Our Ref: 23/03363/HFUL
Your Ref: Heat pump 6 CB22 3ES

South Cambridgeshire District Council
Application for Planning Permission

Proposal: Installation of heat pump to rear.

Site address: 6 High Street Pampisford Cambridgeshire CB22 3ES

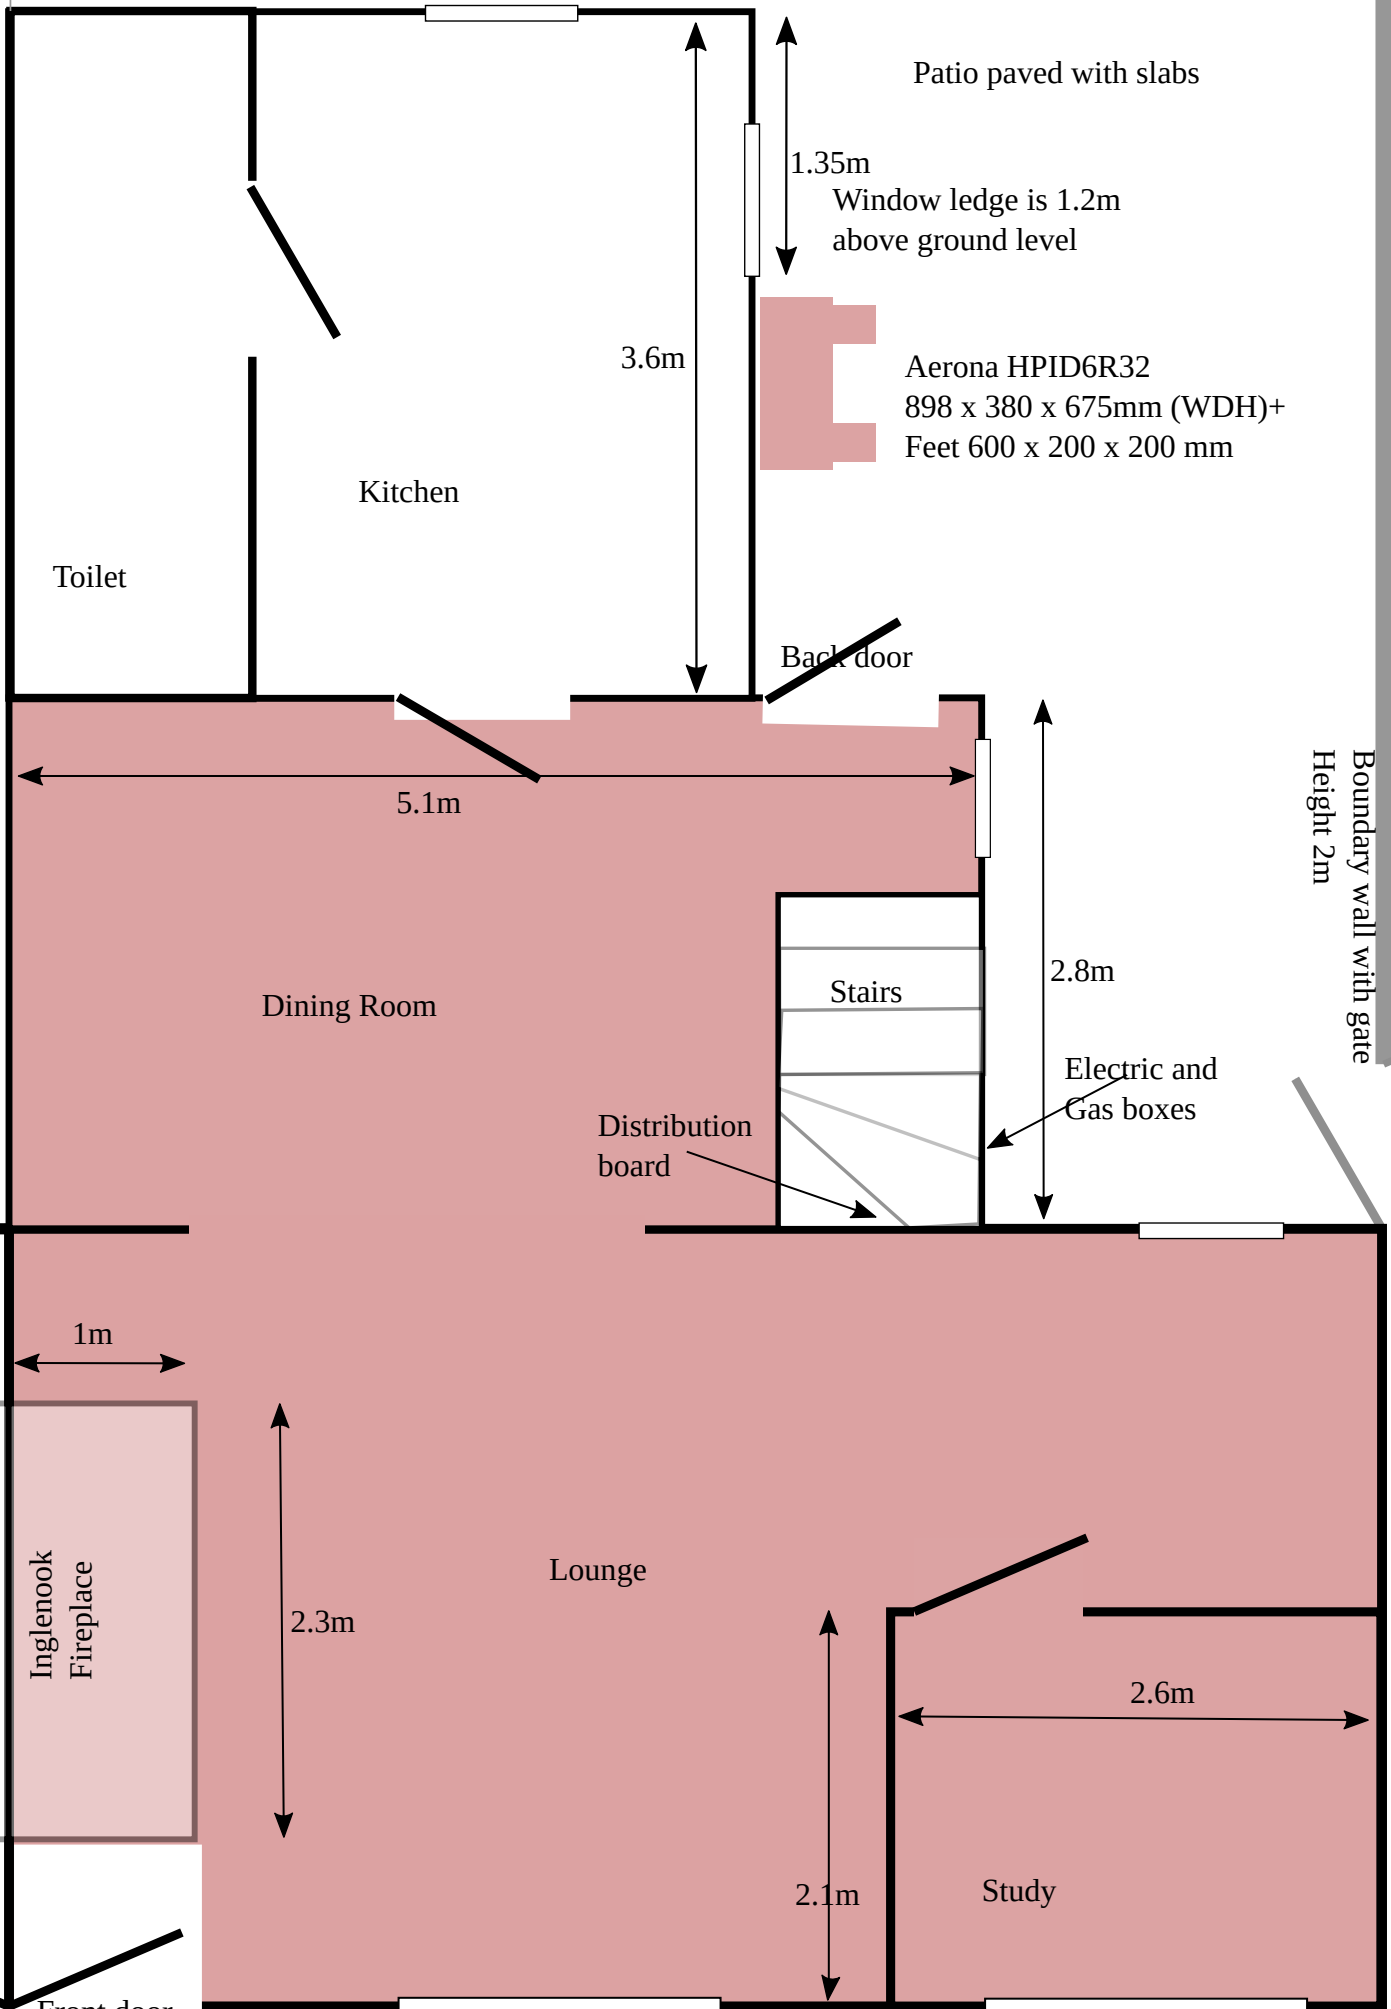
1. Your floor plans should include a suitable scale (For example, 1:200) and measurements that show the distance the heat pump will be from the wall.
